RESPONSE TO SUBMISSIONS

SCEGGS Darlington -
Modification 3
SSD-8993-Mod-3

This Submissions Report relates to a Section 4.55(1A) Modification application in relation to the Concept State Significant Application (concept SSD 8993) for SCEGGS main school campus located at 215 Forbes Street, Darlinghurst (**the site**). On behalf of SCEGGS Darlinghurst Limited (**the Applicant**), this Submissions Report has been prepared to address the matters raised by public agencies, local Council, the community and other relevant stakeholders throughout the public exhibition period.

DWG TITLE  
3D HEIGHT PLANE 4  
DWG NO AR.MP.6004 C  
REV C

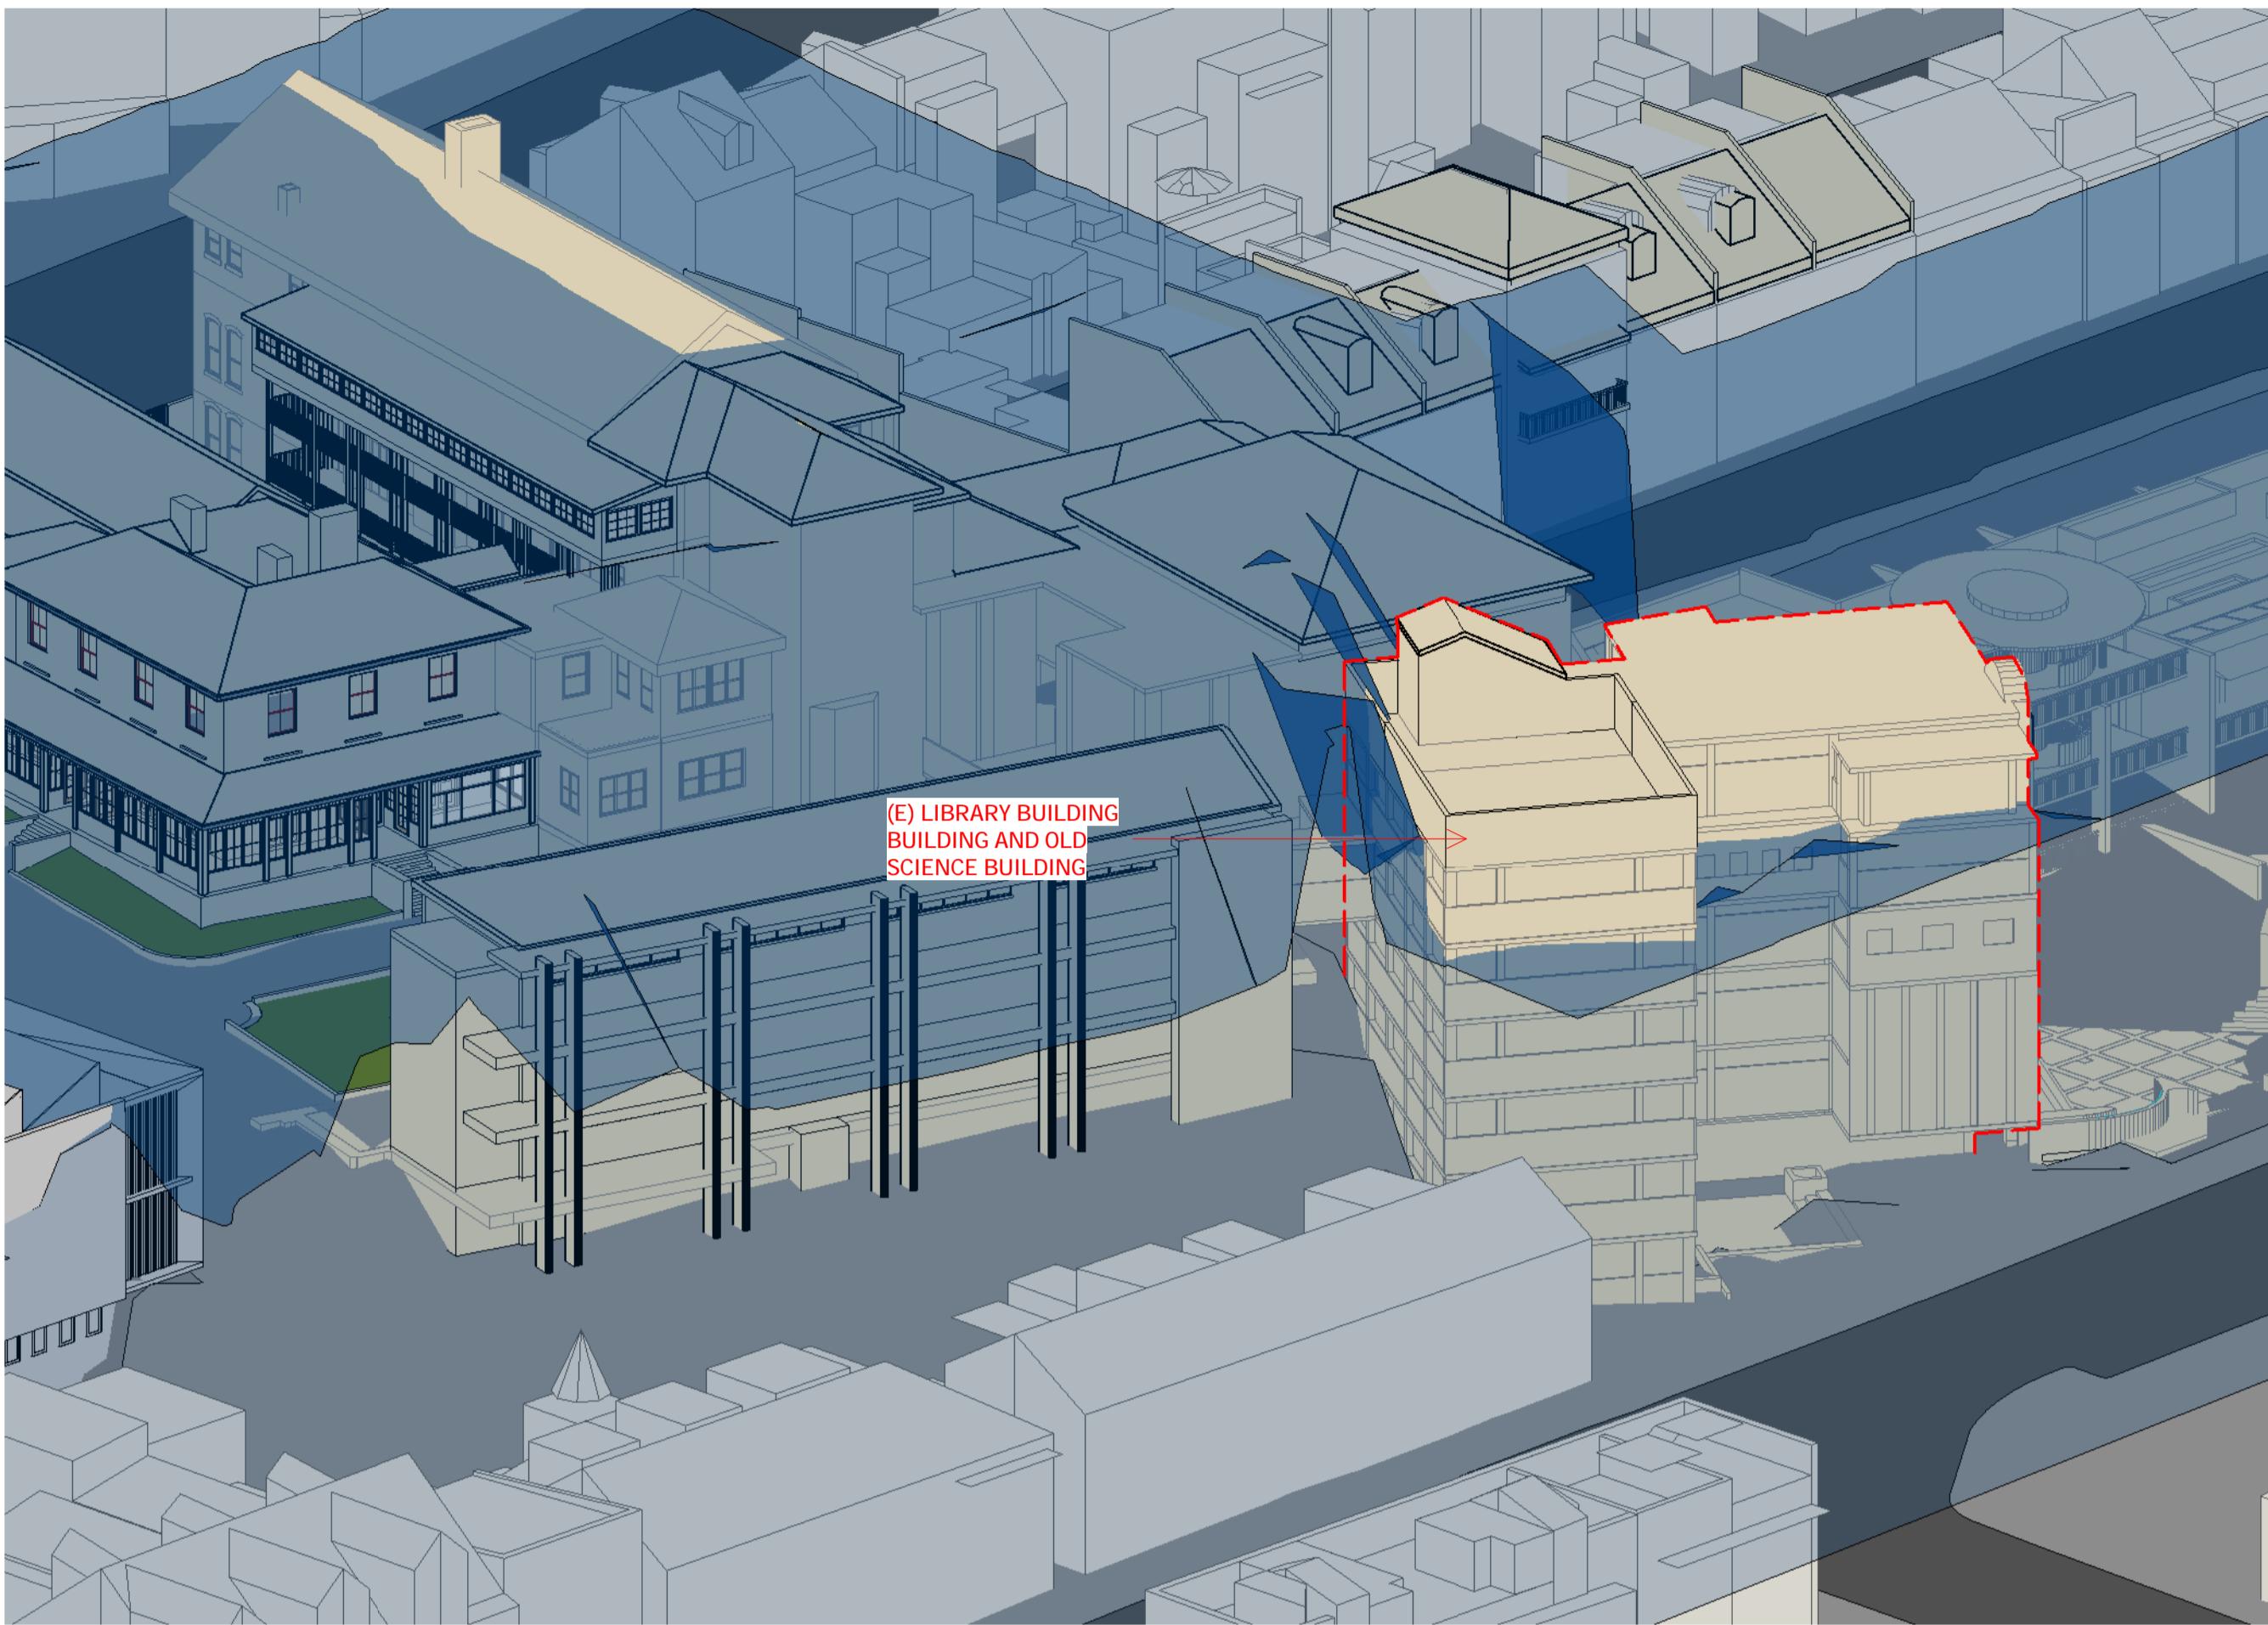
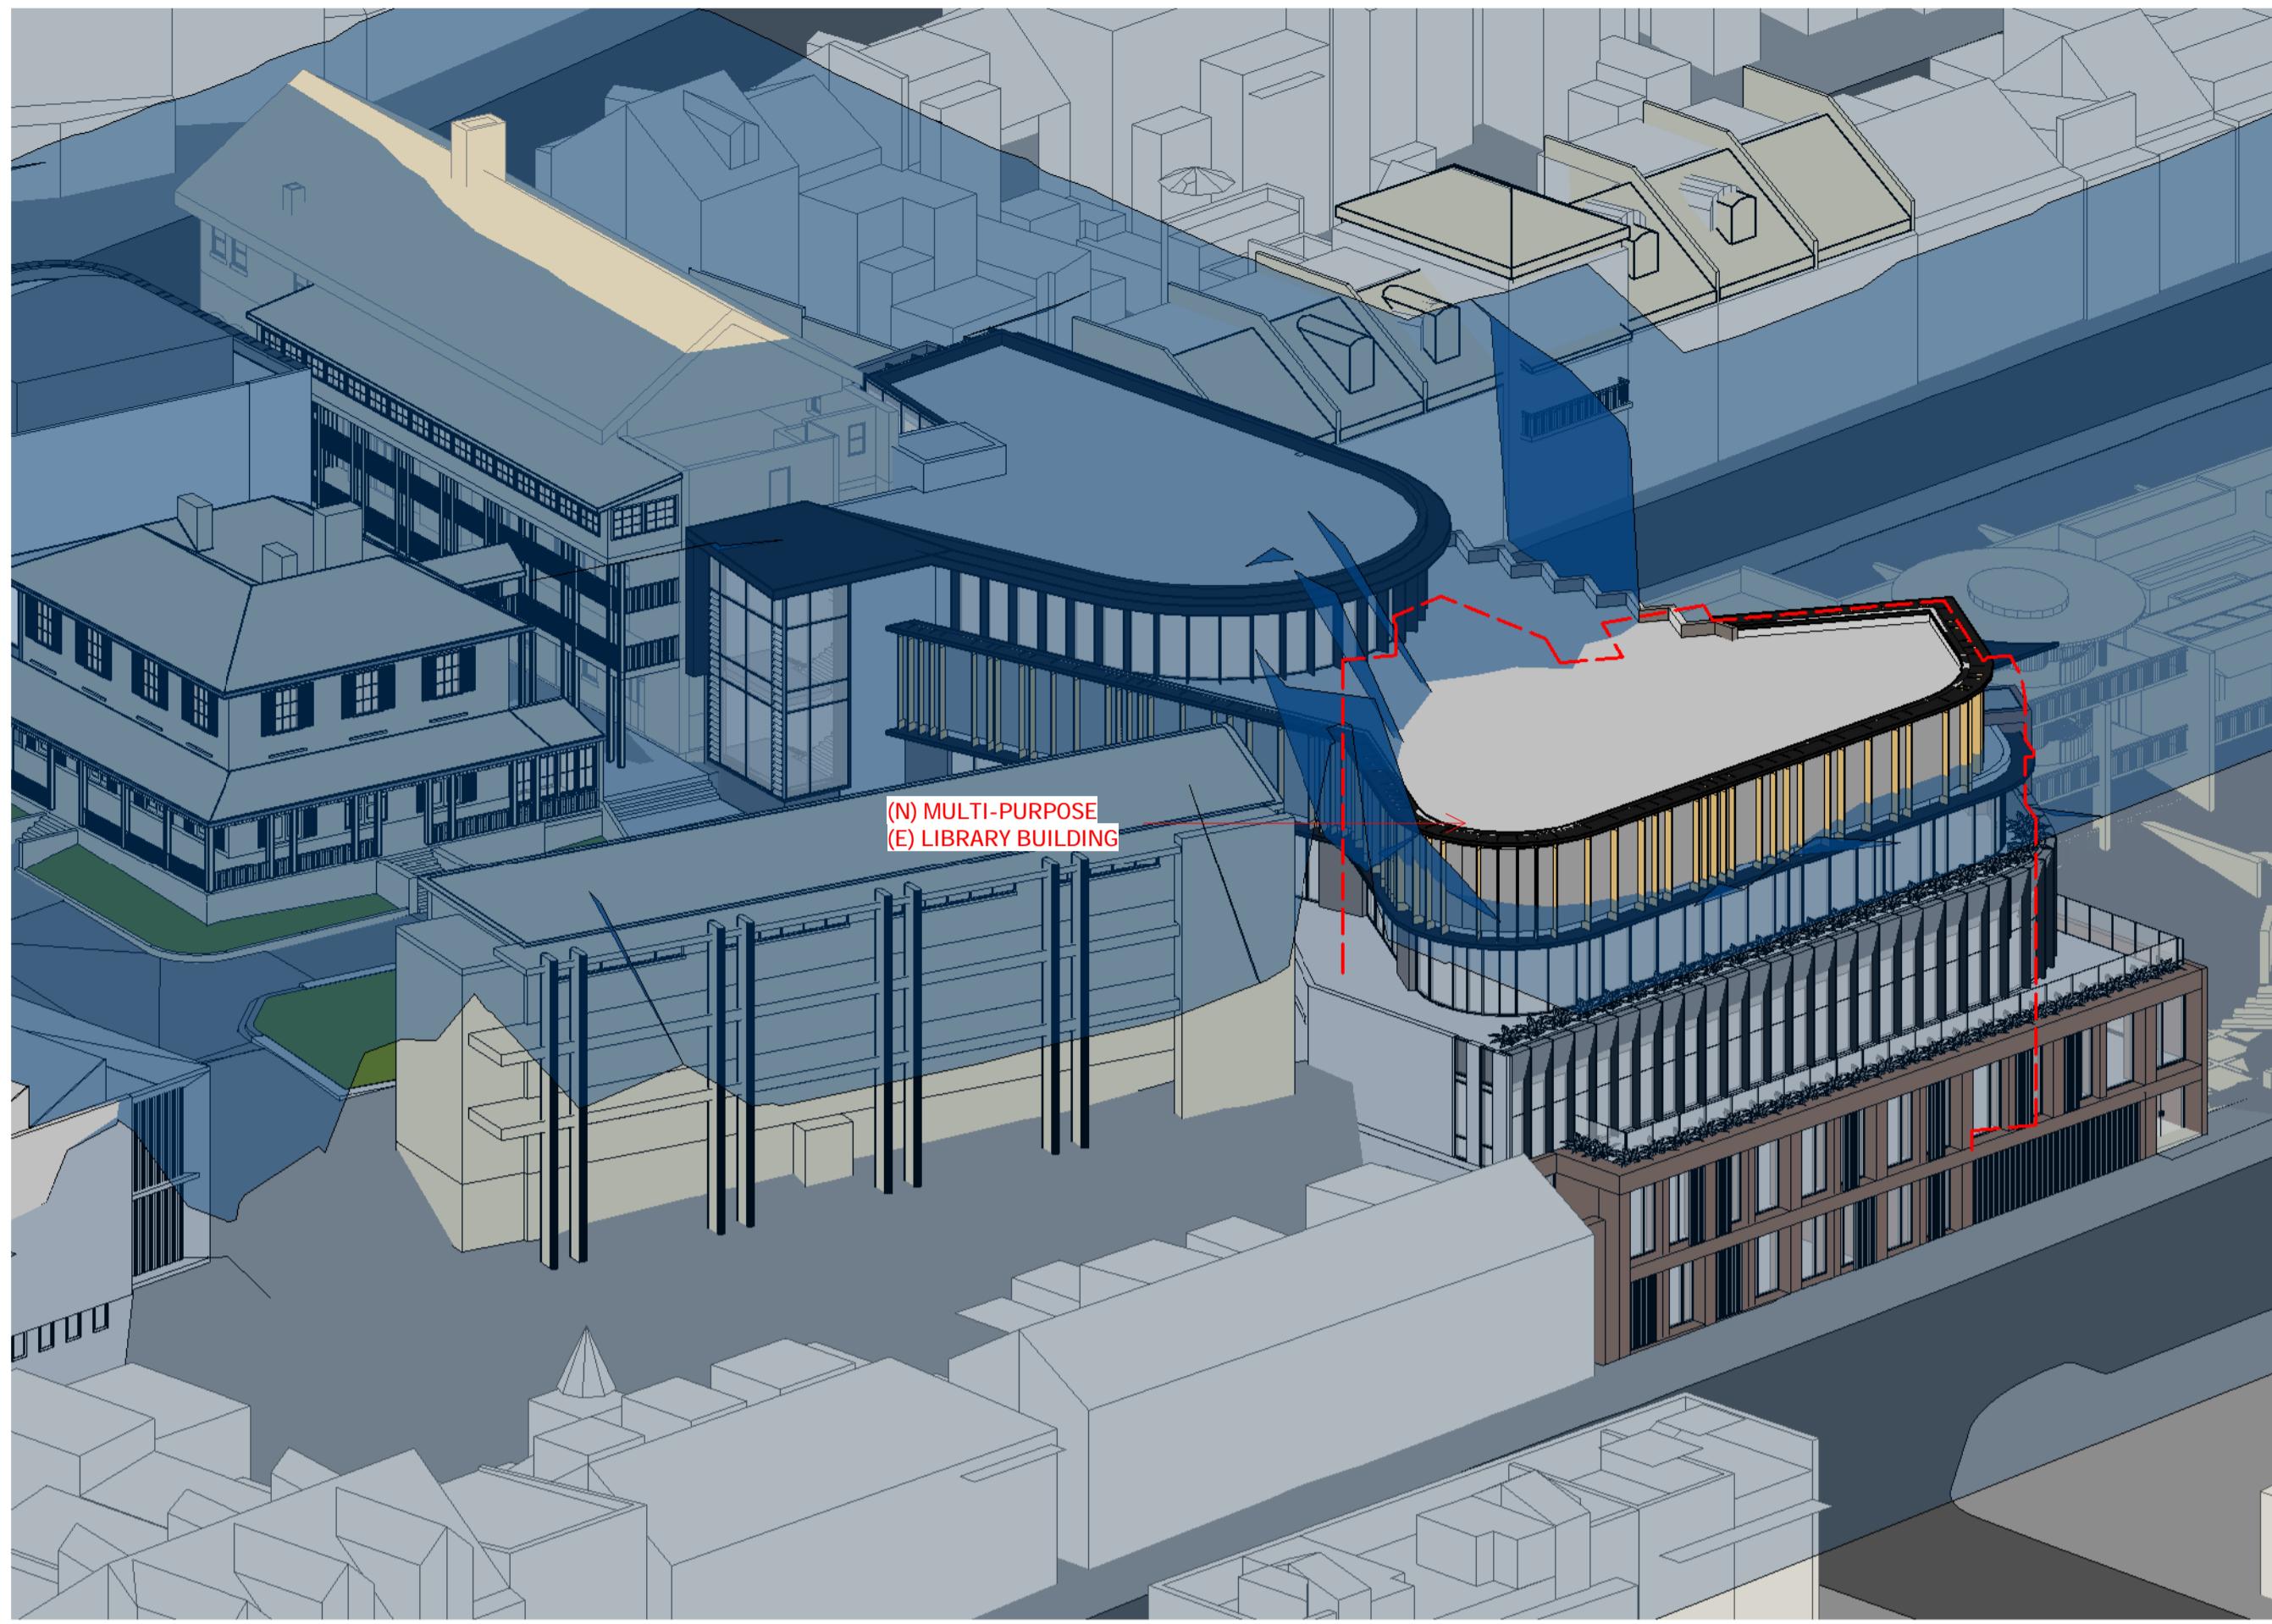
4.2. VISUAL IMPACT OF THE PLANT ENCLOSURE EXTENSION ON THE ROOF OF JOAN FREEMAN BUILDING

The proposal comprised a minor western extension of the building envelope for Wilkinson House to extend above the roof of Joan Freeman building to allow for a plant enclosure for condenser units (as proposed under the concurrent SSDA for Wilkinson House). It is important to clarify that the extension is located on top of the fire staircase portion of the Joan Freeman building (not the main portion of the building), which is further setback from the main façade of the Joan Freeman building.

The building envelope extension has a maximum RL of 45.77, which matches the maximum height of the existing Joan Freeman building (refer to Figure 2). The height of the extension is slightly below the proposed building envelope height of Wilkinson House.

The proposed envelope extension will not be readily visible from the street, because:

- A height datum has already been established by the existing carpark exhaust riser of the Joan Freeman Building, so the envelope extension will blend in with existing service structure.
- The location of the envelop extension is setback from the street and the envelope of Wilkinson House and Joan Freeman building. Therefore is not easily perceived from the street.
- The detailed design of the plant enclosure within the envelope extension is shown in the Detailed SSDA for Wilkinson House. The plant enclosure will be screened, using dark brick treatment to ensure its recessive character.

The proposed envelope extension will not create any adverse visual impact from the street and is considered to be acceptable.
